June 17, 2026

Kittitas County Hearing Examiner

RE: Jentges Conditional Use Permit (CU-26-00001)

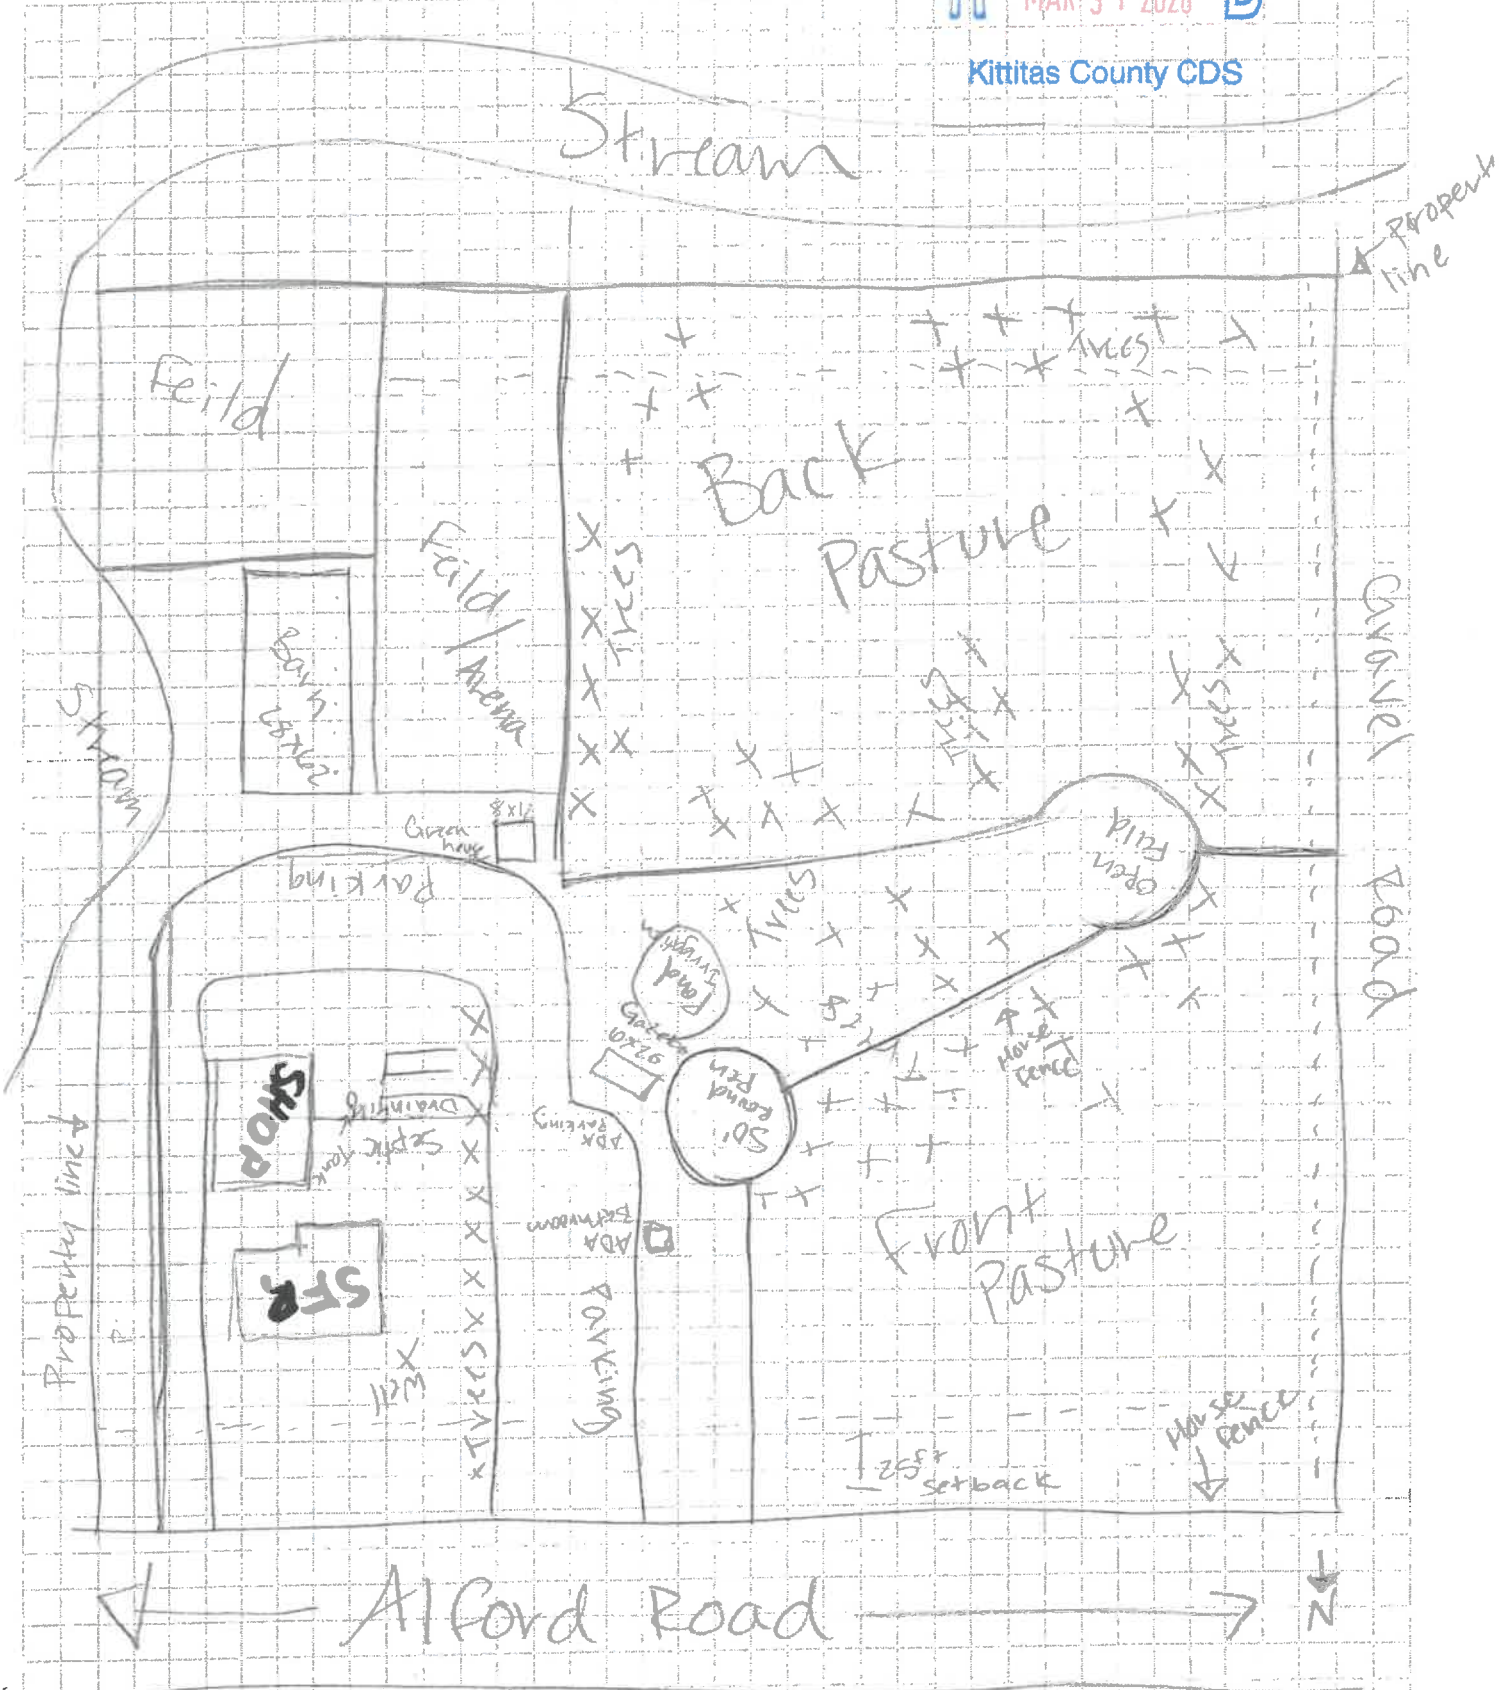
The clearing for the yoga and art meadow has already occurred within the sensitive wetland areas and must be evaluated and mitigated. There has been a reduction in and disturbance to critical areas and buffers by this proposal prior to the review and approval of this Conditional Use Permit or other required permits. No further permits or approvals should be issued prior to the submittal of a Critical Areas Report by a qualified professional and the correction of any current violations or impacts to sensitive and critical areas including existing wetlands and Mercer Creek, a fish bearing and Western Pearlshell Mussel<sup>1</sup> bearing stream.
